**AMENDED PLANS
1 DENISON STREET**

We write to you in relation to 1 Denison Street, North Sydney and the two modifications (Mod 4 & Mod 5) we have lodged in relation to MP08_0238. On Friday Rice Daubney lodged amended plans which should be considered in both modification applications.

DRAWING NUMBER:
DA18INT
REVISION
A

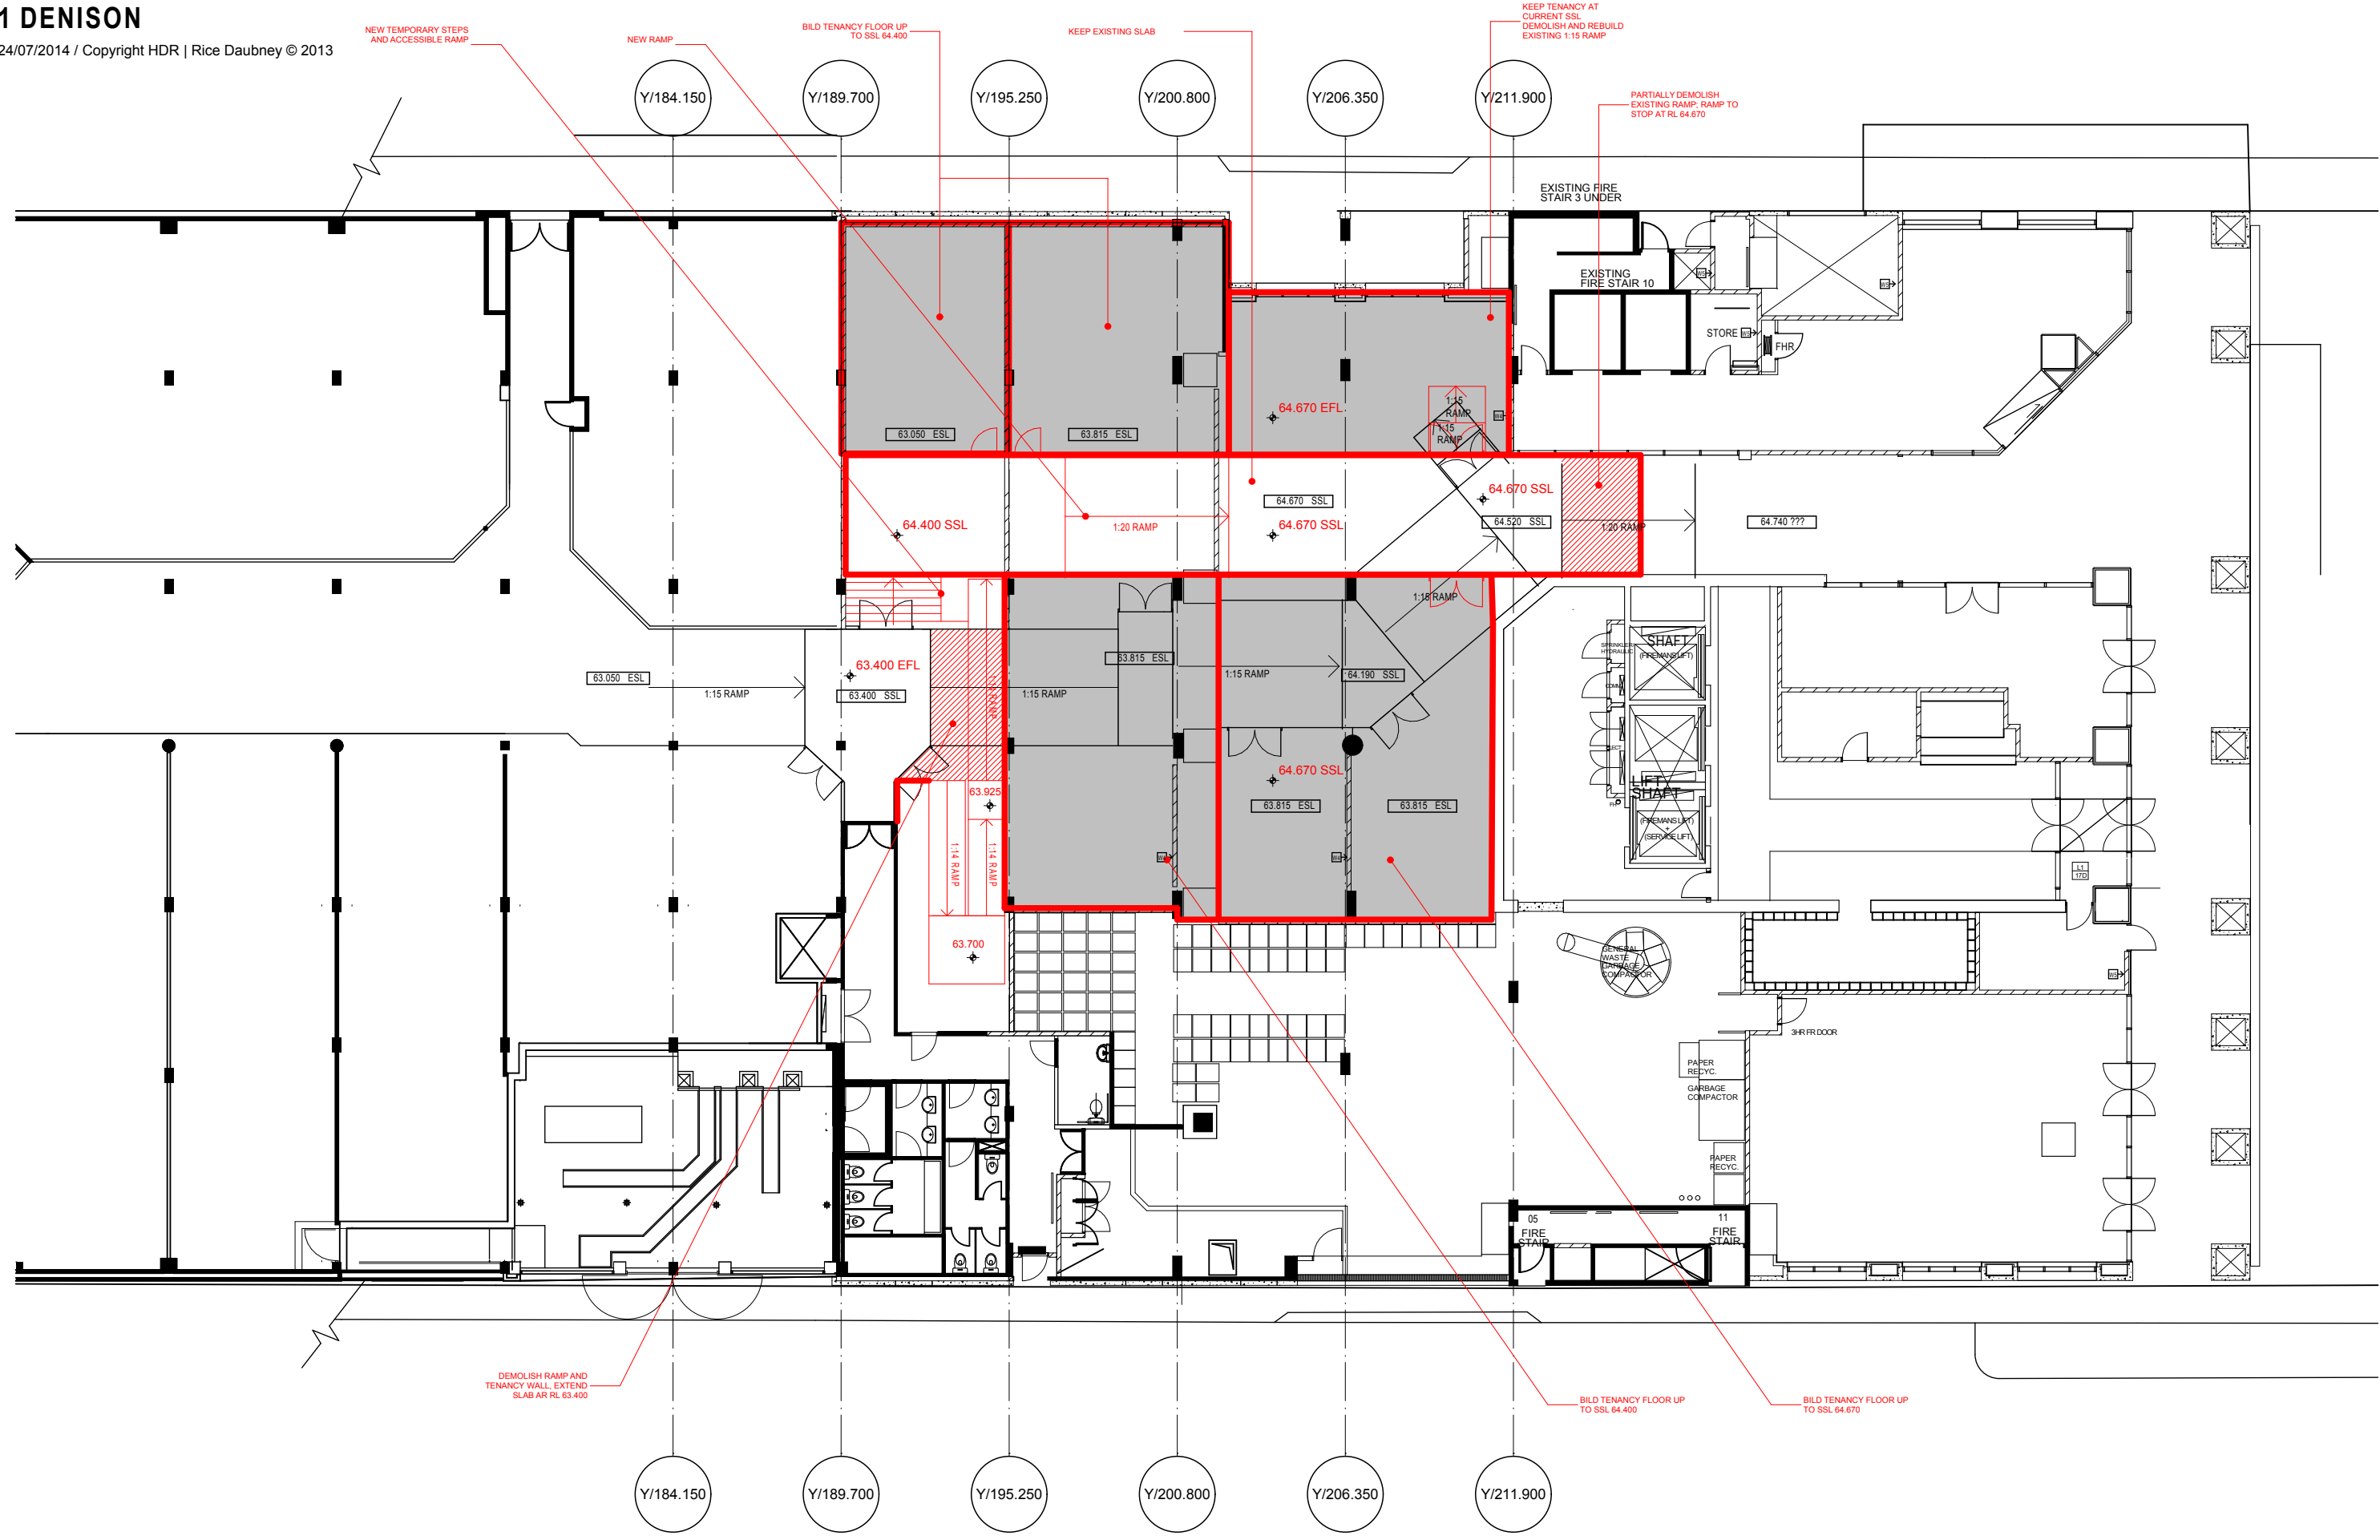
The modifications proposed relate to the refurbishment works that are to be undertaken to the retained portion of the retail podium within the Beau Monde building. As it is likely that these works will be undertaken as one of the first stages of the development the Architects have further developed the design of this aspect of the proposal and have realised that there may need to be a temporary ramp/access solution in place to deal with the differing site levels until such time as the Shopping World building is demolished and rebuilt. In light of this there is a new plan to be inserted in the drawing set (DA18INT Rev A) which shows the temporary solution which the drawing DA18 Rev J shows the final developed solution upon completion of the project.

Small changes have also been made to DA18 in relation to the final configuration of the ramping of the through site walkway due to the existing site constraints which have been discovered during the detailed design phase.
